# OXFORDSHIRE COUNTY COUNCIL'S RESPONSE TO CONSULTATION ON THE FOLLOWING DEVELOPMENT PROPOSAL

**Application no:** 22/01683/F

**Proposal:** Development within Use Classes E (g) (i), and/or (ii), and/or (iii), and/or B2 and/or B8 and Associated Works including Access and Parking

**Location:** Unit 7, Oxford Technology Park, Technology Drive, Kidlington, OX5 1GN

content : BUILDING 7
PROPOSED CYCLE LOCATIONS

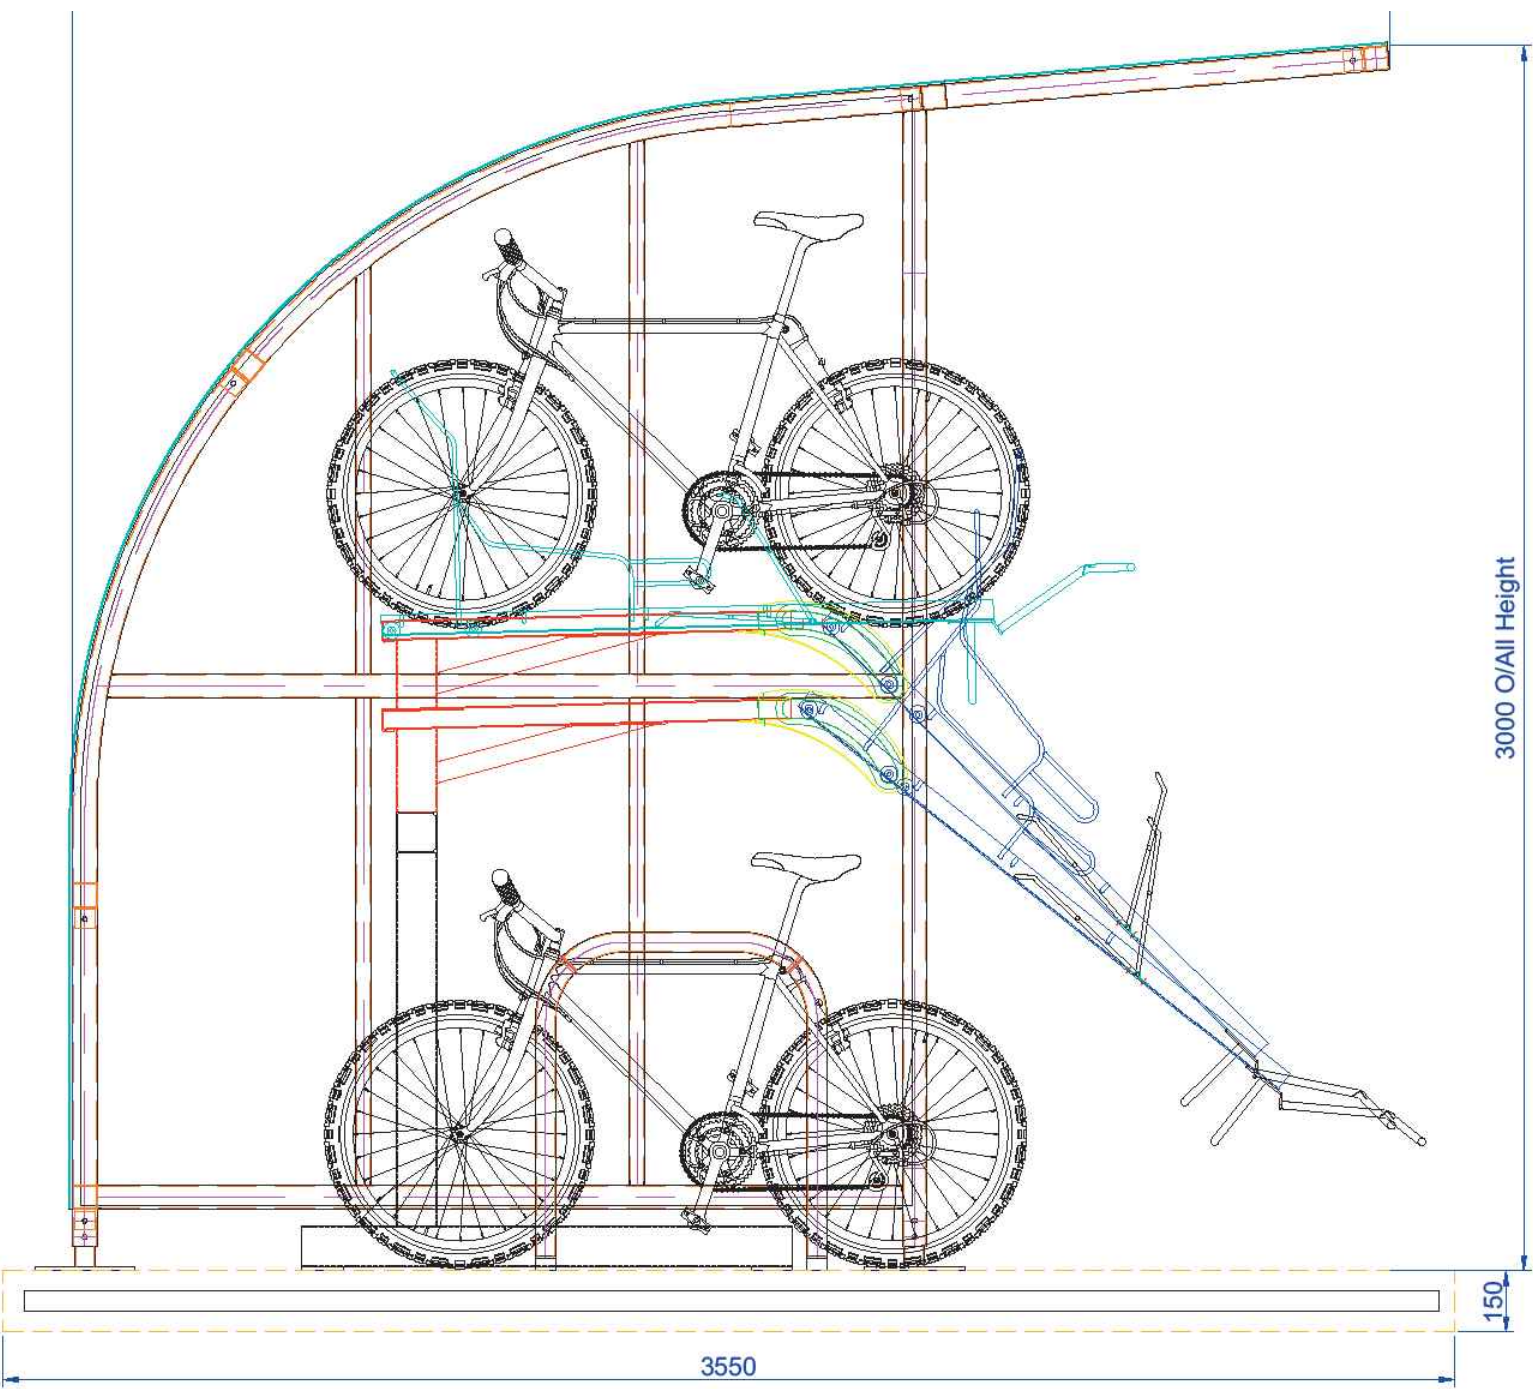
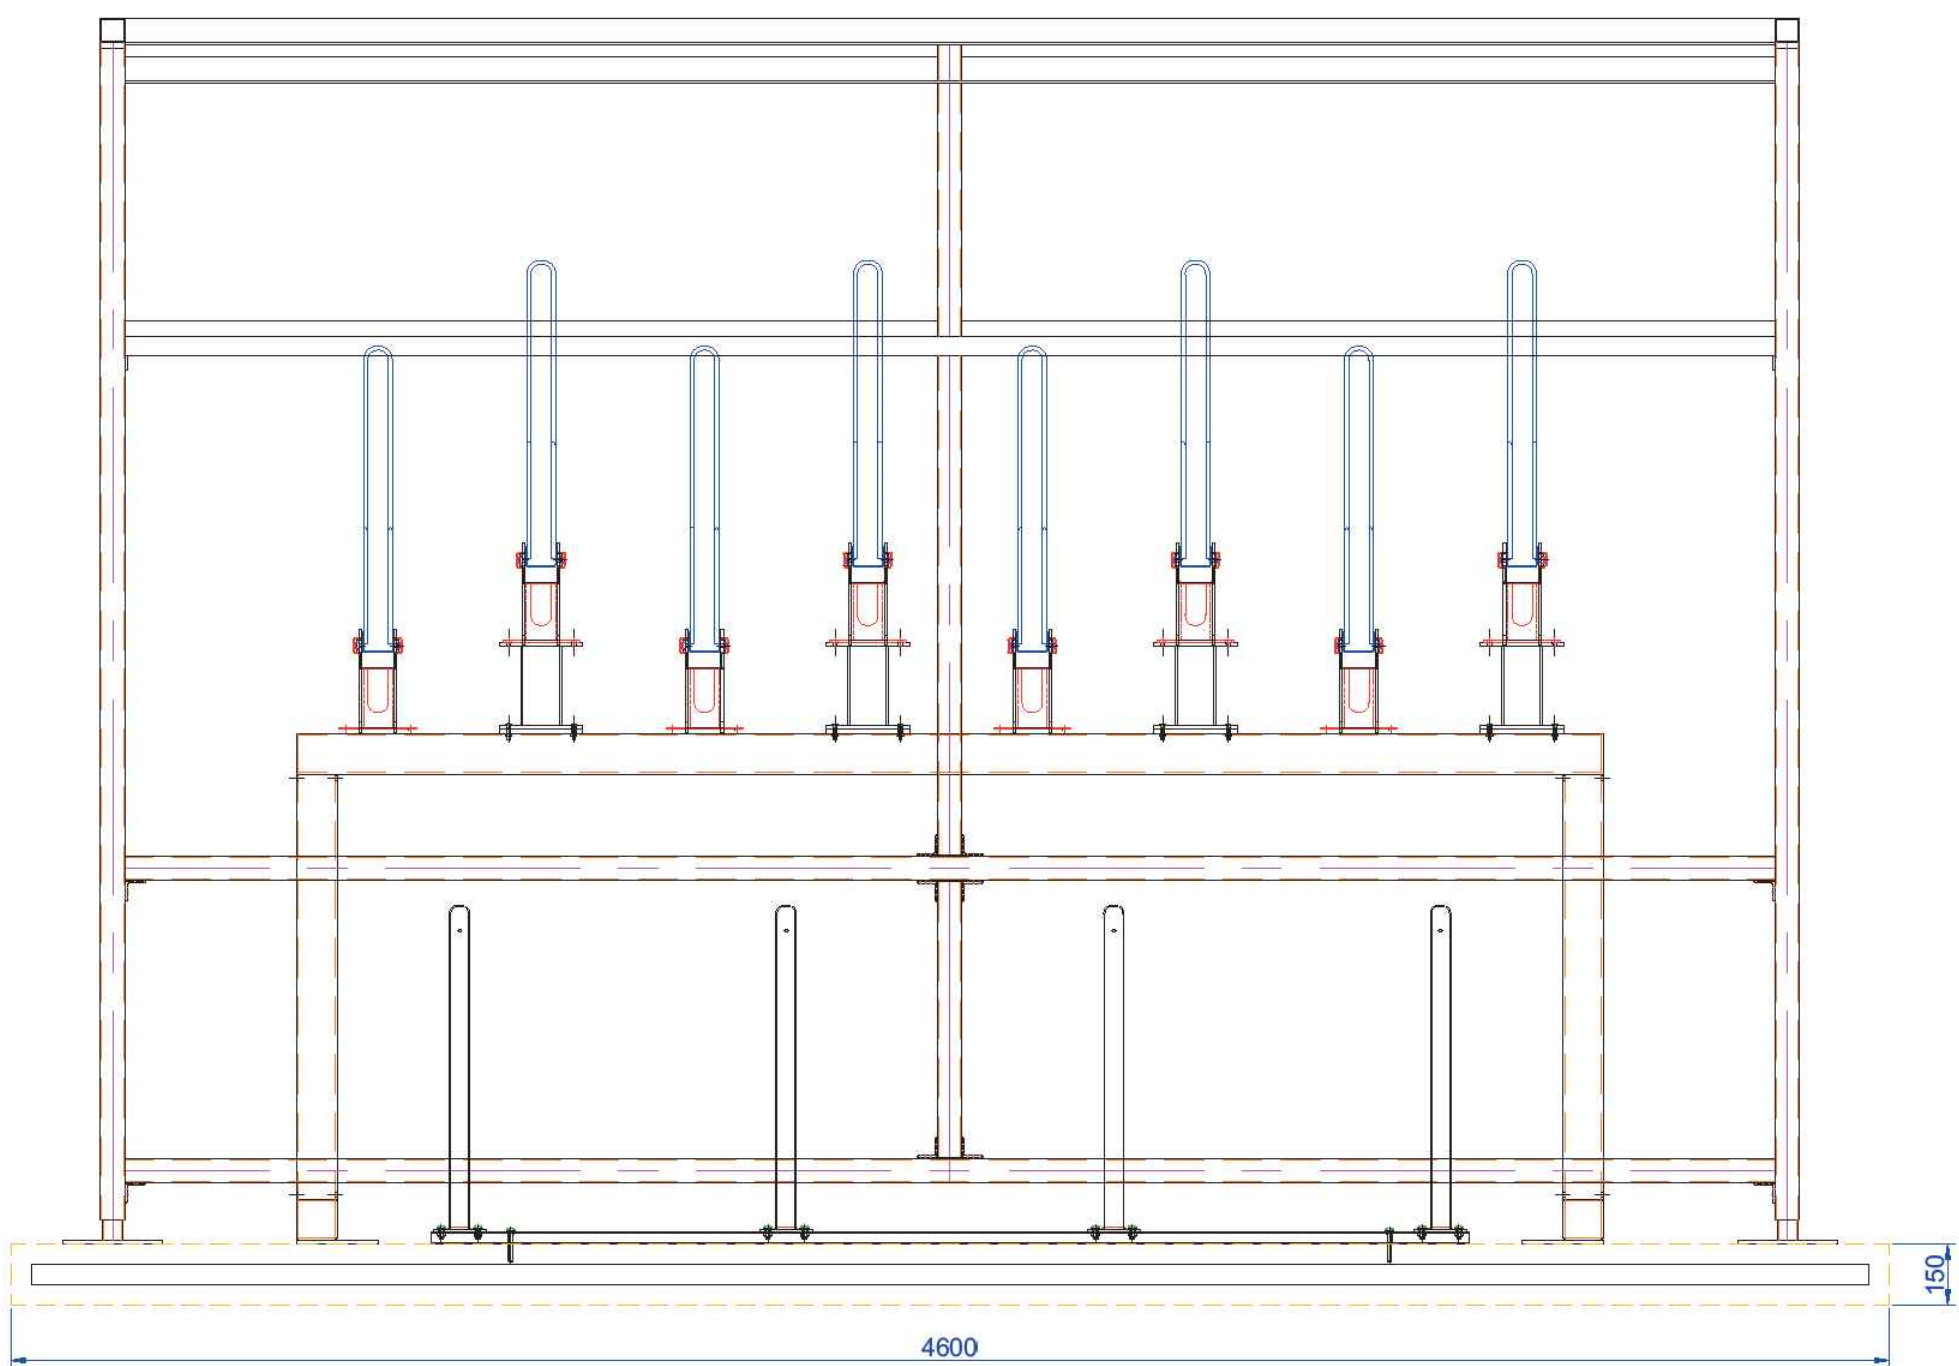
A total of 40 cycle stands are being provided and in accordance with Oxfordshire County Council cycle parking standards based on the parking ratio for units 7 (1space for 111square metres). The proposed cycle parking is not ideal for a number of reasons and should be reconsidered. 'Sheffield' type stands are the most accessible for all cyclists and are the preferred option.
